Amended Concept Proposal for Eastern Creek retail outlet centre (SSD-10457)

Heritage NSW (HNSW) have reviewed the amended concept proposal with respect to State Heritage Register (SHR) items and historic archaeology. It is noted that the amendment primarily involves a revised intersection design at Church Street and Rooty Hill Road South which encroaches into the SHR item *The Rooty Hill* (SHR 01756). The roadworks impact 0.39ha of Cumberland Plain Woodland at the south-western corner of the SHR item and will require the dedication of the land comprising the new road to RMS.

Aerial photograph showing the subject site, outlined in red, the listed heritage items in the vicinity, and the proposed intersection circled in yellow

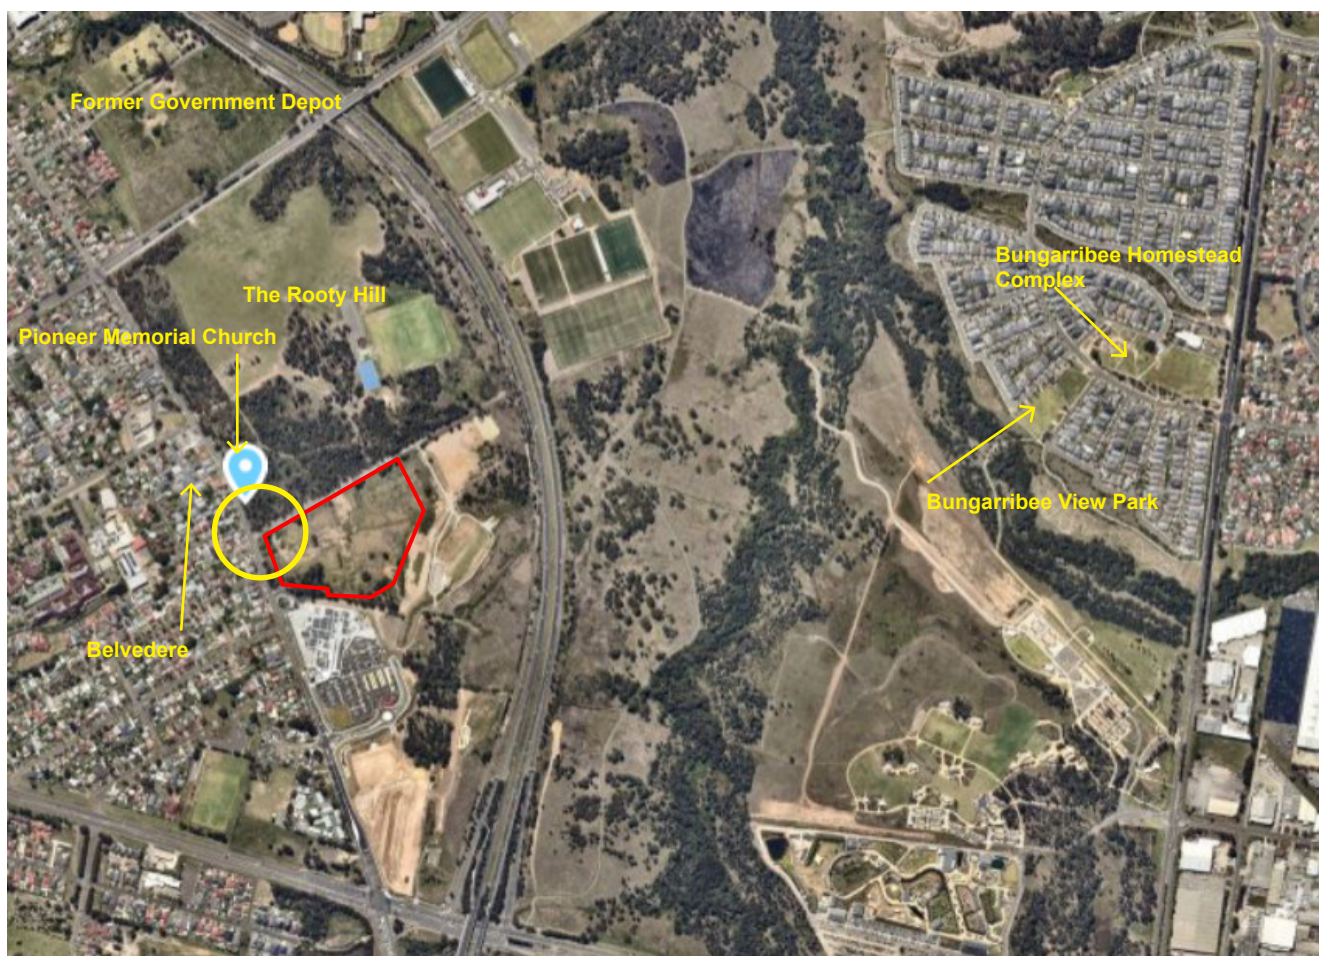
- The updated Heritage Impact Statement (GBA Heritage, July 2022, Issue H) states that the revised intersection will have an acceptable heritage impact on the Church located within *The Rooty Hill* and to views to and from *The Rooty Hill*. HNSW considers the proposed tree removal and the construction of the intersection to have an acceptable heritage impact provided that the tree removal is limited to the area of roadwork. It is unclear from the documentation provided as to the extent of tree removal, and it is recommended that this be clarified through an Arborist report that identifies all trees to be retained and protected within *The Rooty Hill* in the vicinity of the proposed works.
